Pre-Design Investigation
(Additions)

ADDRESS 1026 Eubank N.E.

A PROPOSED ADDITION  
FOR  
ELOY'S MEXICAN KITCHEN  
ALBUQUERQUE, N. MEX.

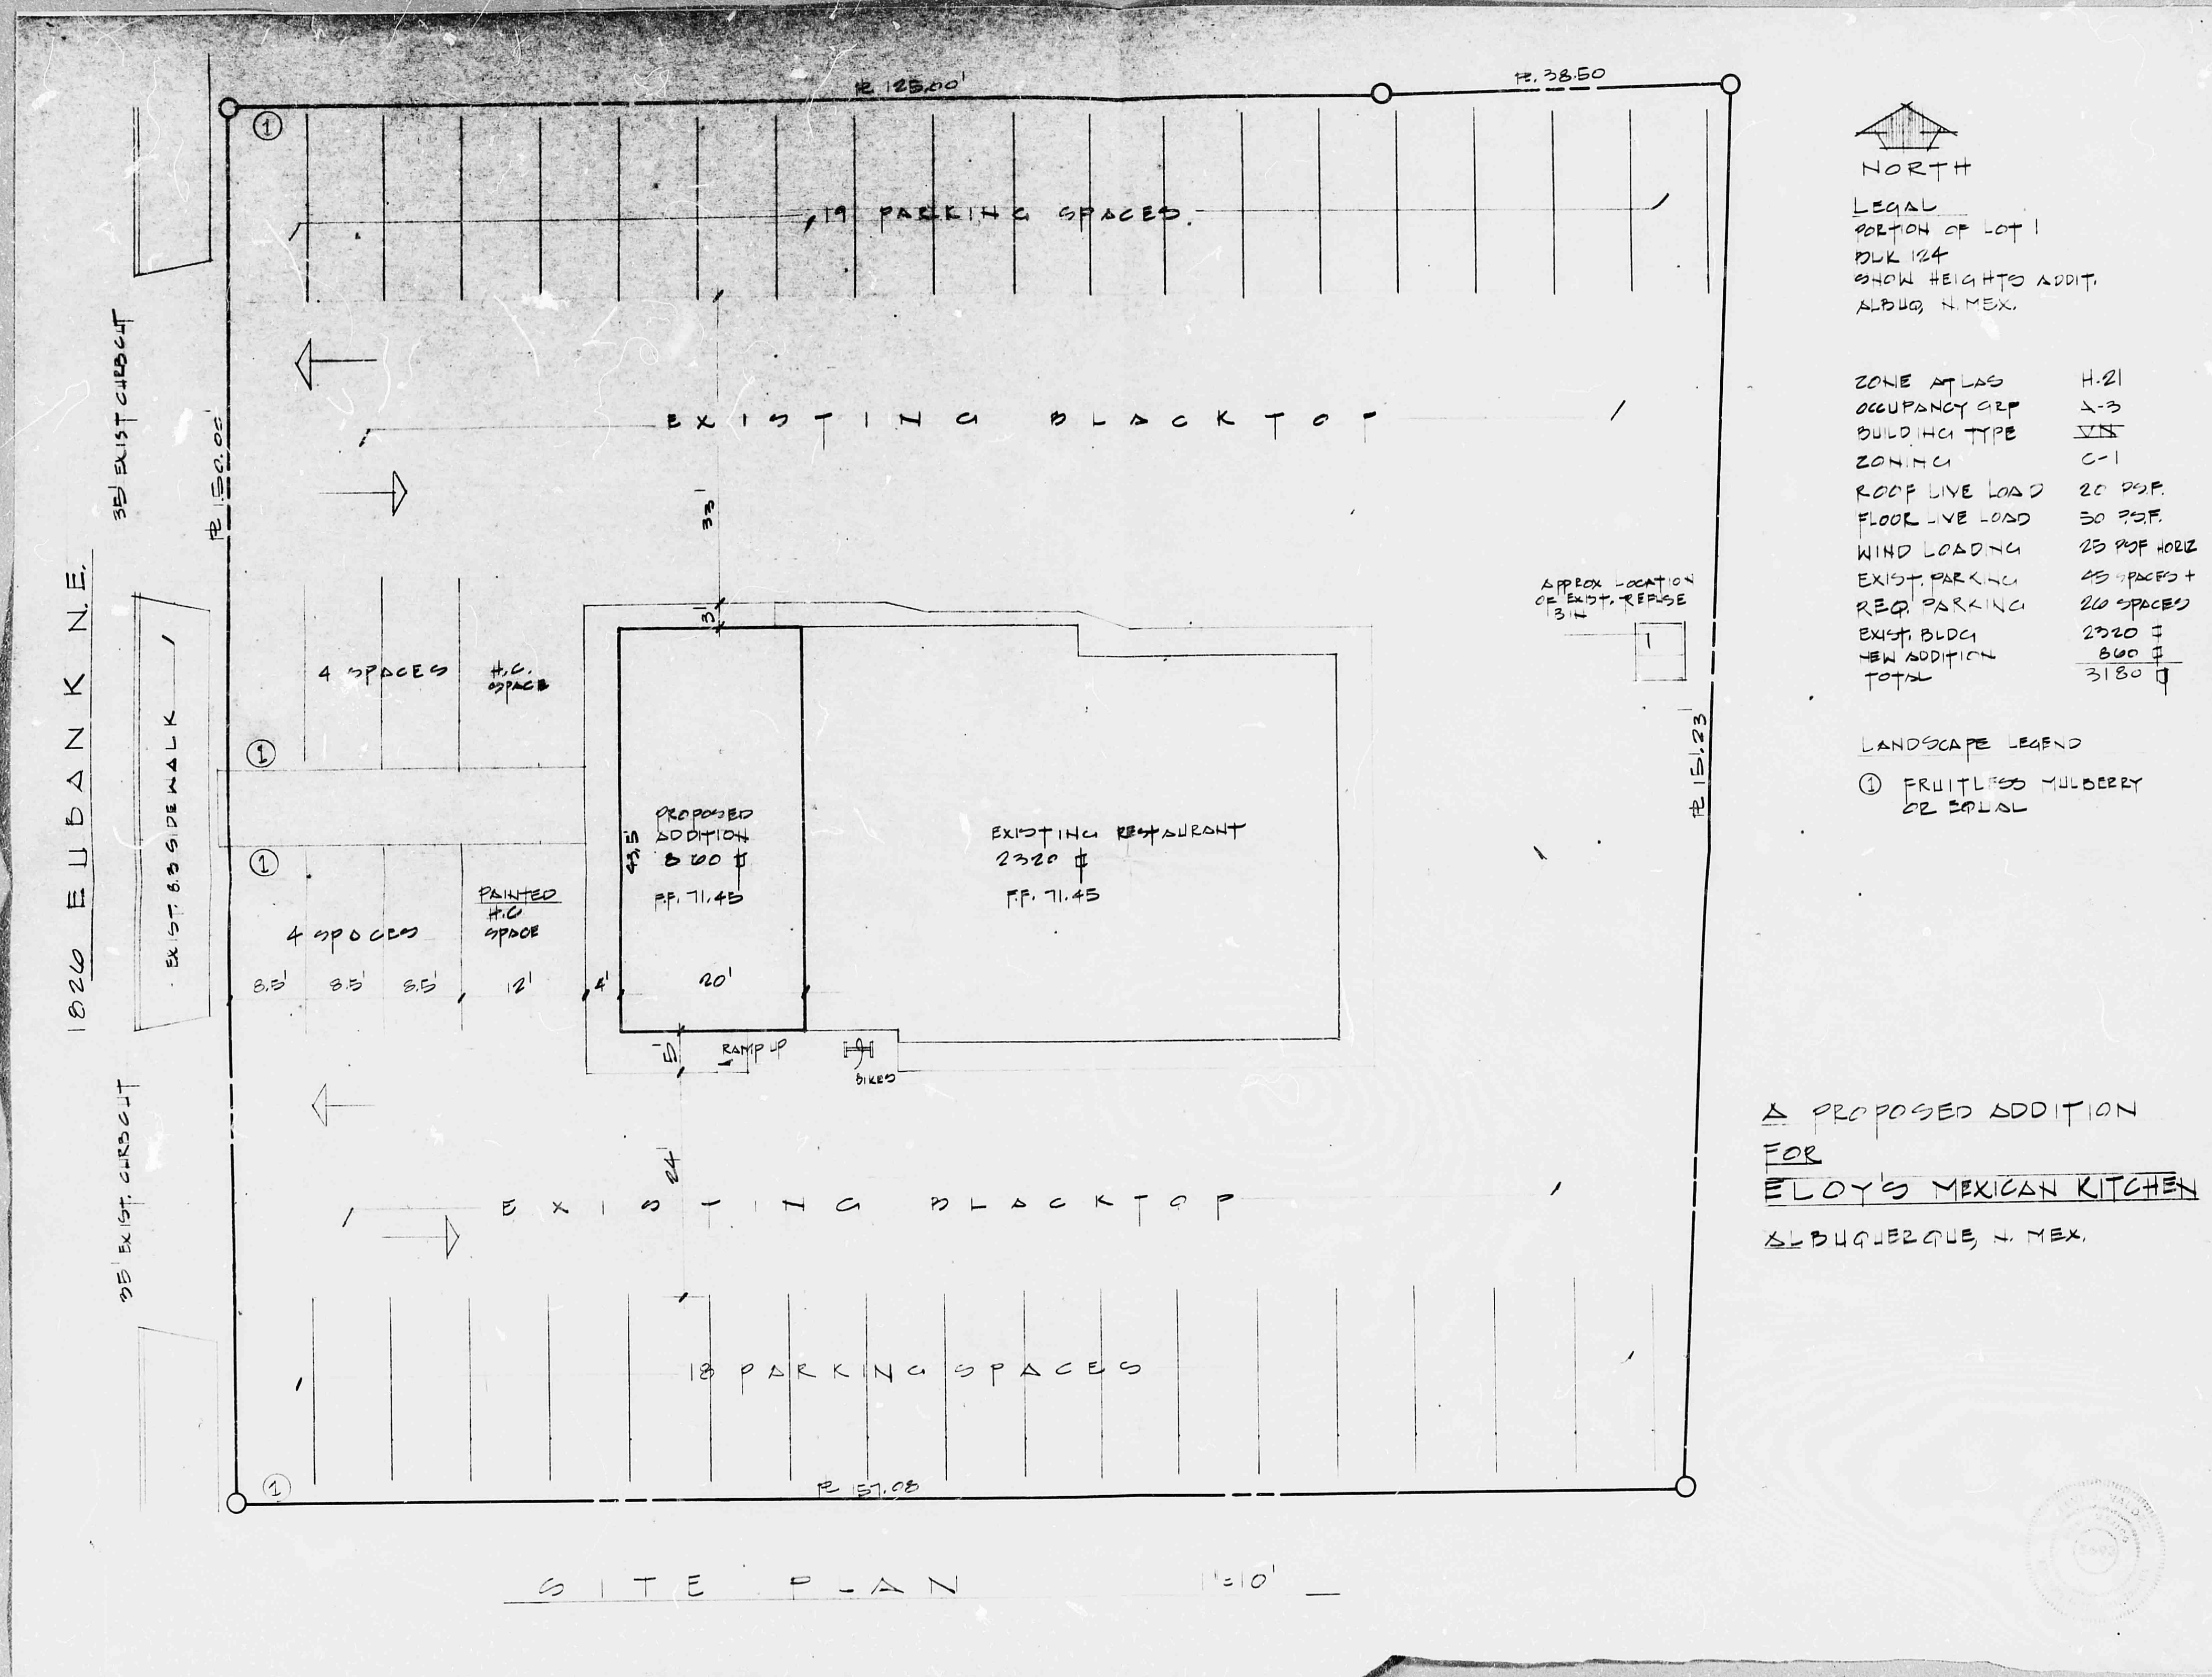
Existing asphalt, no requirements

Site plan showing existing drainage pattern

THERRA, MAKE A
FILE AND ROUTE
BACK FOR ME.
THIS IS A NEW
PLAN AND IT IS
APPROVED 3/4
